MEMORANDUM

TO: Jean Fraser
FROM: Dan Goyette, PE and Lauren Swett, EIT
DATE: April 24, 2008
RE: Portland Museum of Art, Spring Street Site Plan

Woodard & Curran has reviewed the site plan application for the Portland Museum of Art Spring Street parking lot. The Museum has purchased the former YWCA property located at the corner of Spring Street and Walnut Street, and is proposing to construct a 45-vehicle parking lot for museum employees. The project will include extensive landscaping and the construction of a bioretention cell for stormwater treatment.

2 CATCH BASIN  
NOT TO SCALE

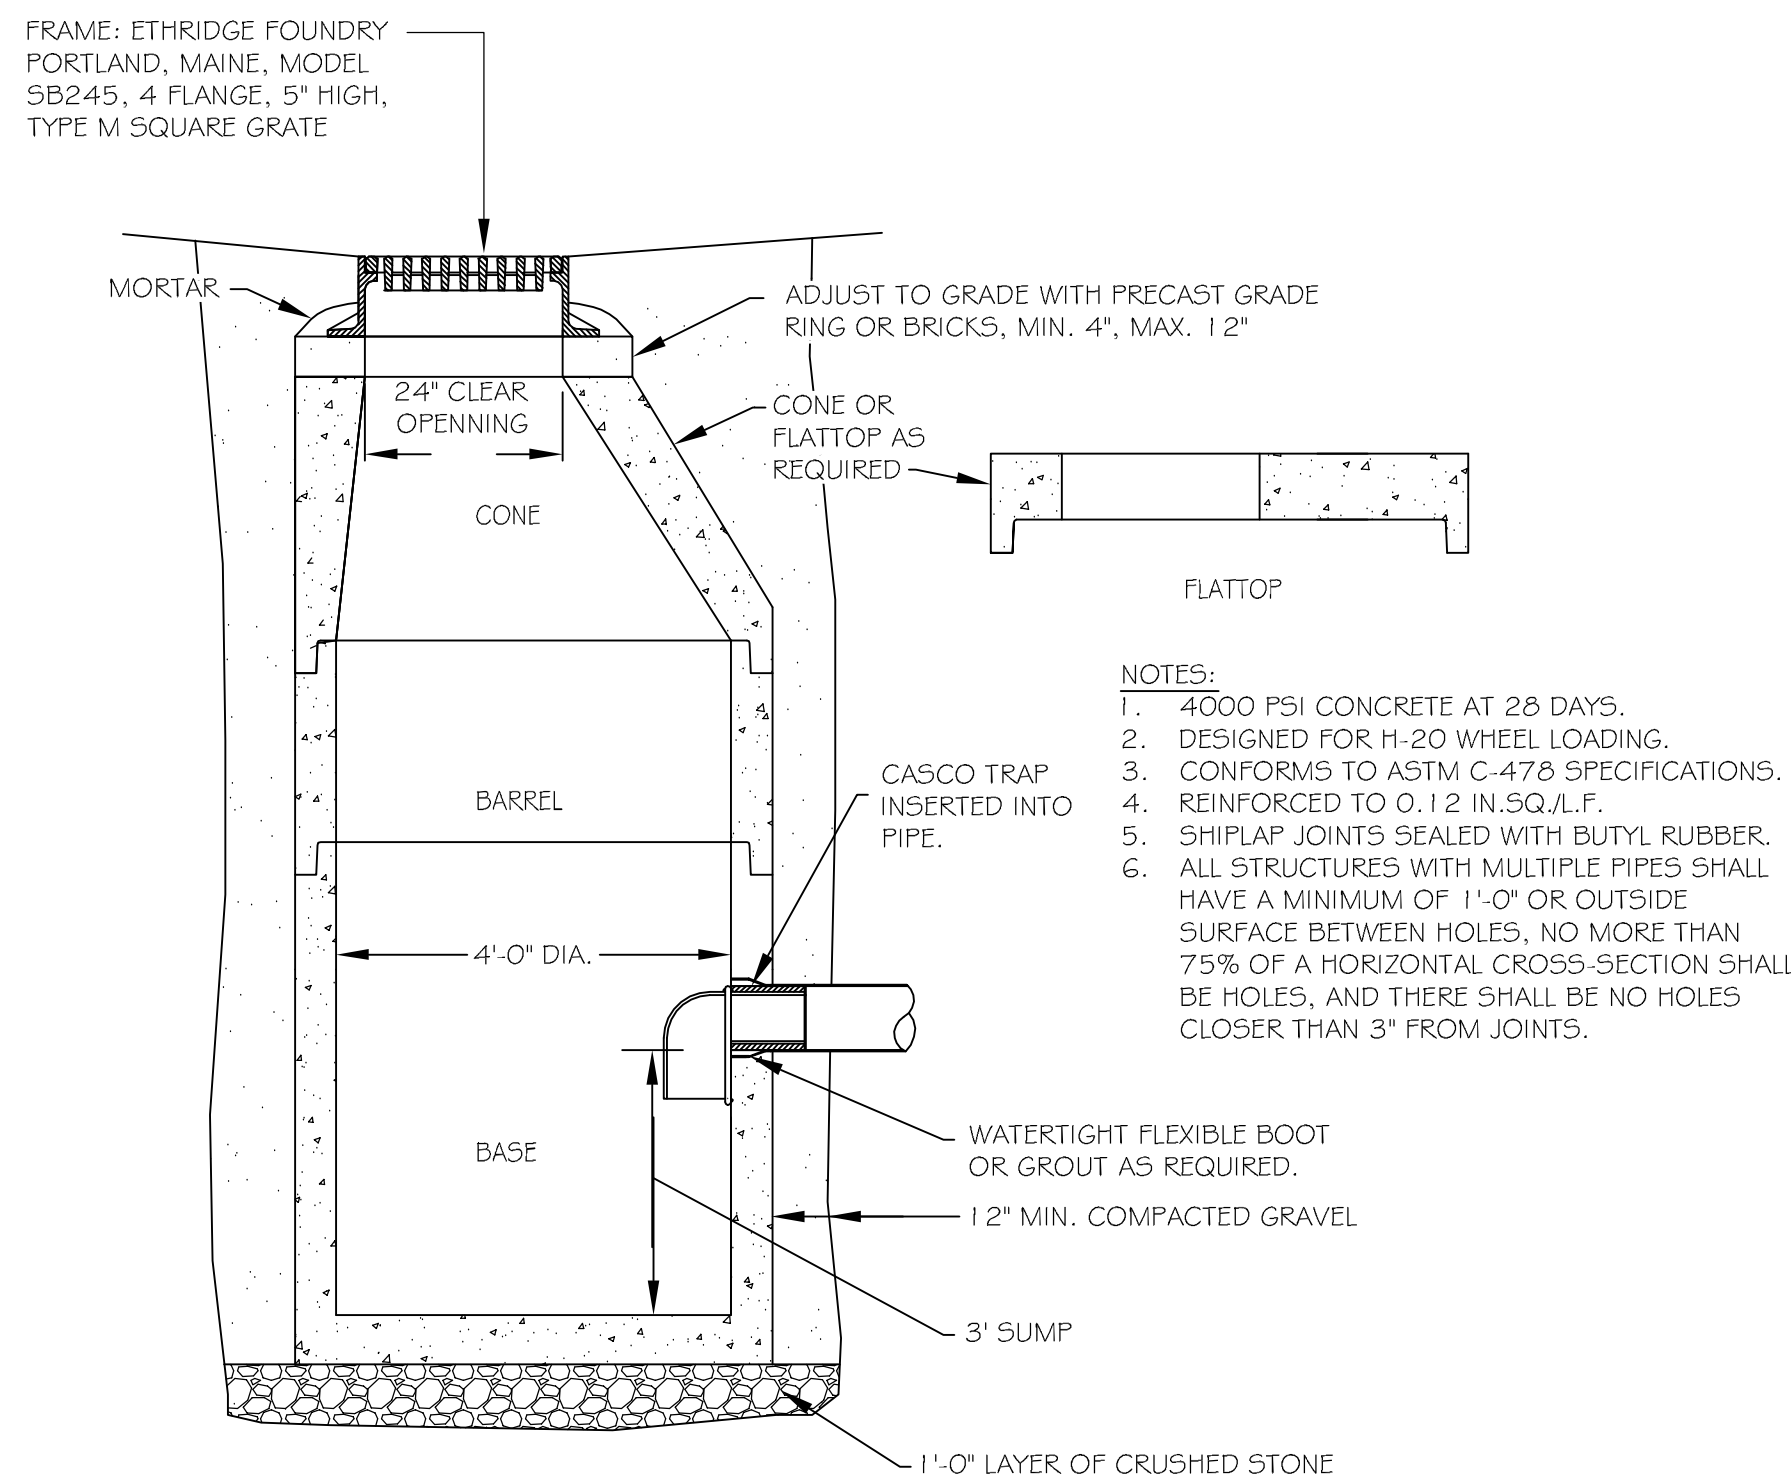
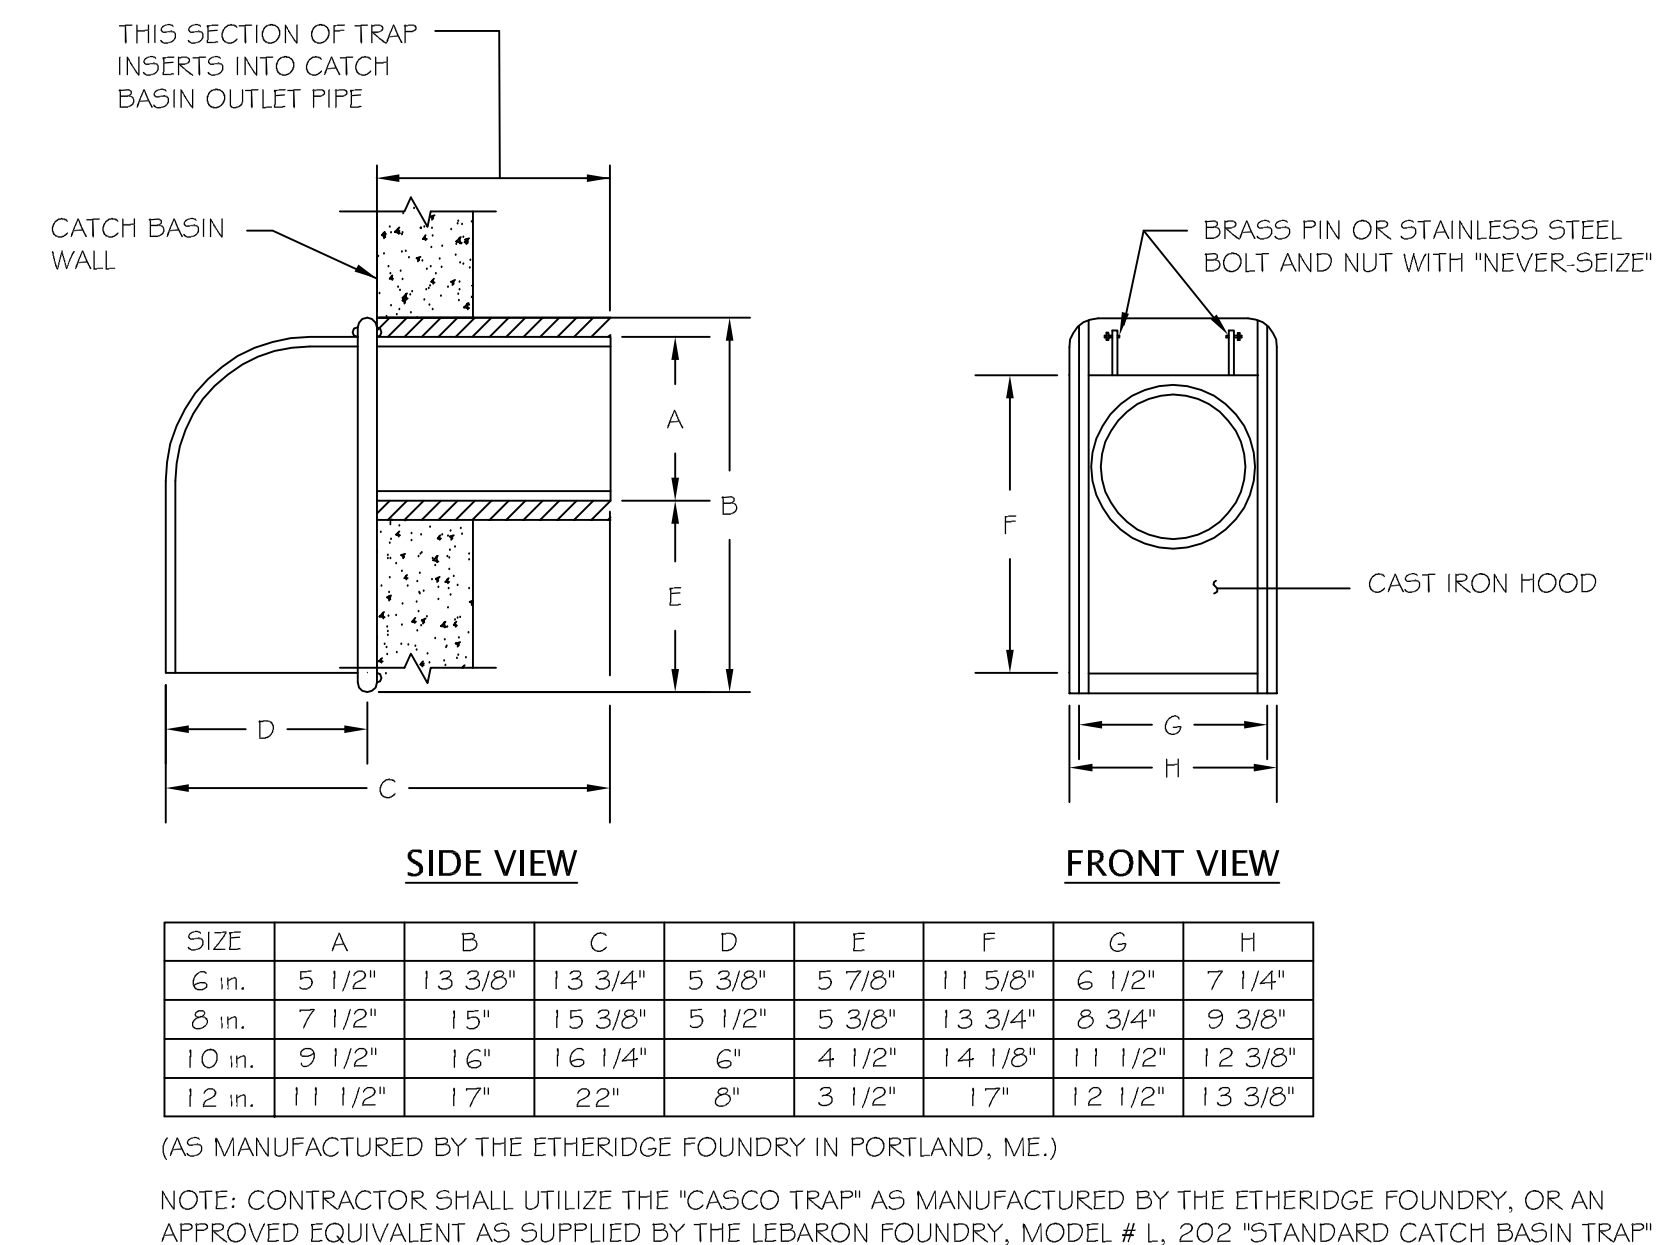
- Catch basins should have casco traps. A detail should be included and the casco trap should be shown in the catch basin detail as well.
- The bioretention cell detail does not include a depth for the soil filter bed.
- It was noted that the proposed bioretention cell has a ponding depth of 18". MaineDEP standards for BMPs call for a maximum ponding depth of 6" to allow for plant growth. We recommend that the applicant contact the DEP to discuss allowable ponding depth relative to the plants that have been chosen for the site.
